## **OXFORDSHIRE COUNTY COUNCIL'S RESPONSE TO CONSULTATION ON THE FOLLOWING DEVELOPMENT PROPOSAL**

**Application no:** 21/04275/OUT

**Proposal:** OUTLINE - with all matters reserved except for Access - Mixed Use Development of up to 3,100 dwellings (including extra care); residential and care accommodation(C2); mixed use local centre (comprising commercial, business and service uses, residential uses, C2 uses, local community uses (F2(a) and F2(b)), hot food takeaways, public house, wine bar); employment area (B2, B8, E(g)); learning and non-residential institutions (Class F1) including primary school (plus land to allow extension of existing Gagle Brook primary school); green Infrastructure including formal (including playing fields) and informal open space, allotments, landscape, biodiversity and amenity space; burial ground; play space (including Neaps/Leaps/MUGA); changing facilities; ground mounted photovoltaic arrays; sustainable drainage systems; movement network comprising new highway, cycle and pedestrian routes and access from highway network; car parking; infrastructure (including utilities); engineering works (including ground modelling); demolition

**Location:** Adj

Bucknell Road to be closed to vehicles,
Maintained as pedestrian / cycle route

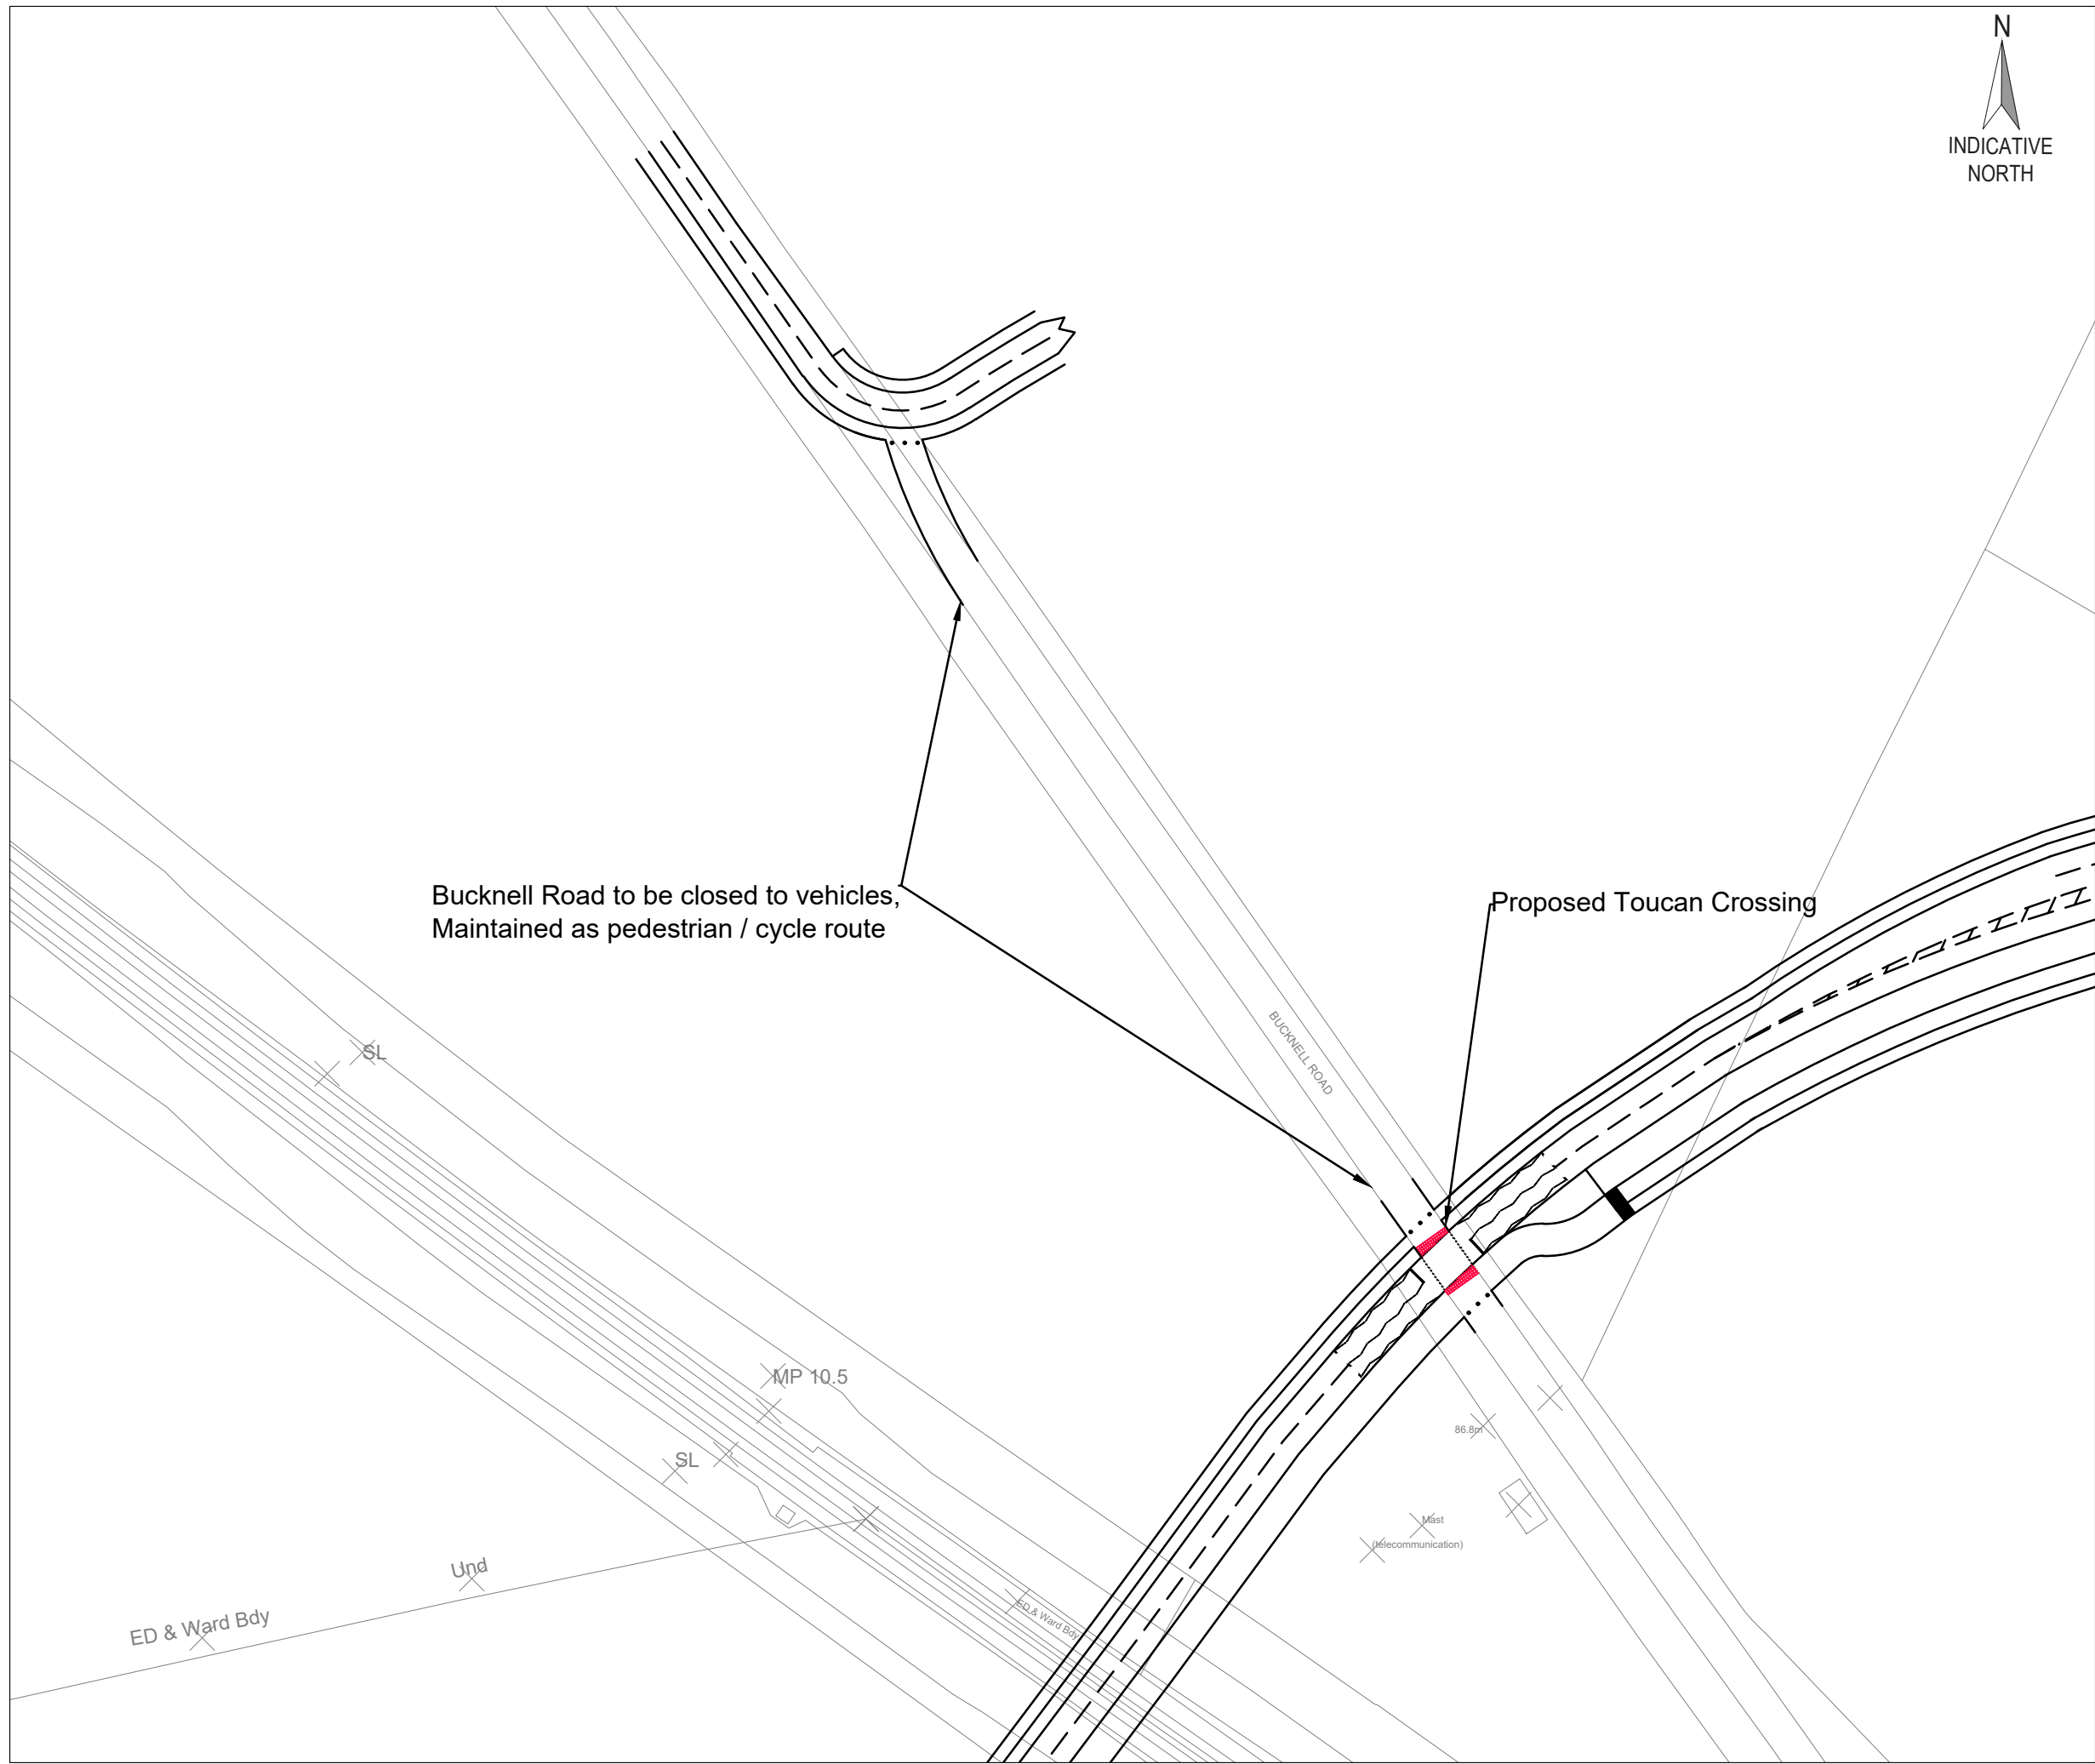
A secondary access is proposed onto Bucknell Road between the local centre and the school, linking to the spine road. Bucknell Road would be closed to traffic south of this point, forming a ped/cycle route only, with a toucan crossing of the realigned A4095. It is proposed to introduce traffic calming northwards along Bucknell Road to deter ratrunning.

4. The secondary access off Bucknell Road is much further south than in the NW Bicester Masterplan and as such it would be less effective at deterring rat running through Bucknell. The application proposes traffic calming all the way along Bucknell Road. Upgrades to traffic calming in Bucknell village would also be required. This would need to be sufficiently deterrent, yet designed sensitively bearing in mind funeral corteges accessing the new cemetery. Further details are required.

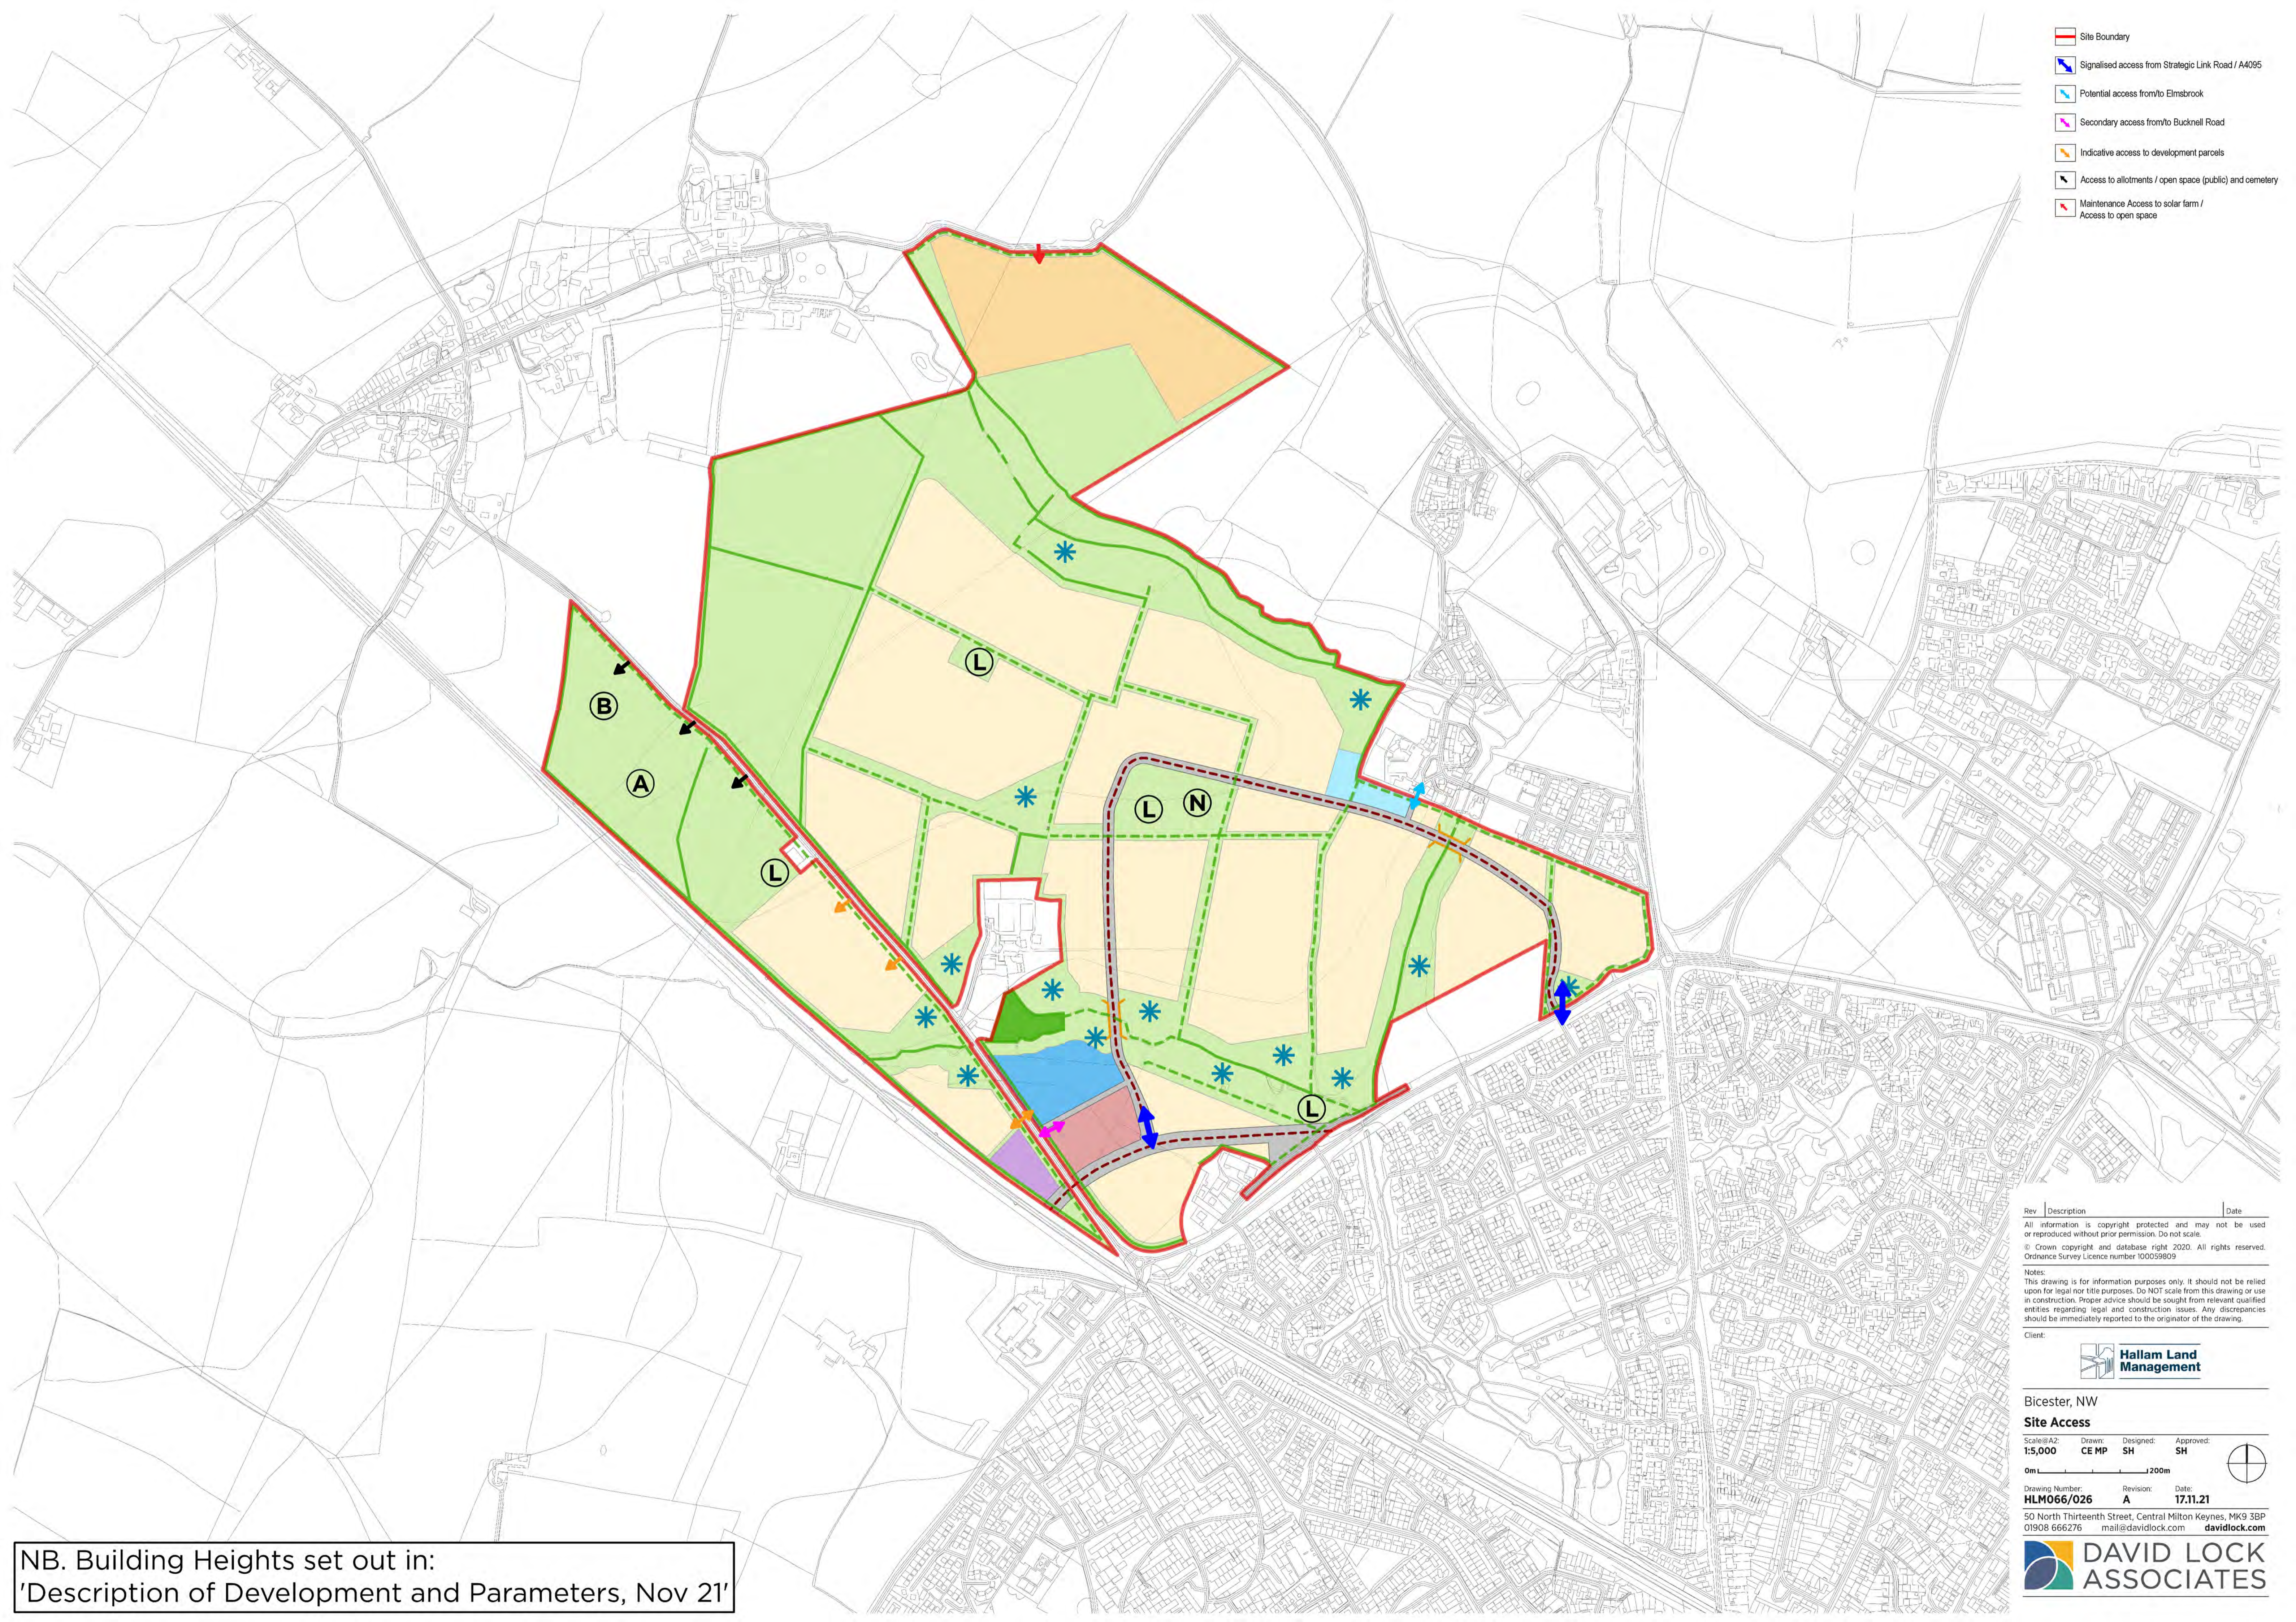
An access into Elmsbrook (the Exemplar site), in the position indicated in the NW Bicester Masterplan, is shown as 'potential'.

Other accesses onto Bucknell Road are mentioned but no details are provided. This includes accesses into residential parcels, a business centre and a new cemetery. Also an access is proposed off Bainton Road but no details are provided. There are no details of pedestrian/cycle accesses into the site other than at the vehicular access points.

2. A further access is proposed on Lords Lane but it is not clear where and there are no details - this needs to be clarified,

5. No details are provided of the proposed accesses off Bucknell and Bainton Road - as the application is for access in detail, scale drawings must be provided showing visibility splays.

6. The access into Elmsbrook, shown as 'potential' must be provided for bus, cycle and pedestrian access.
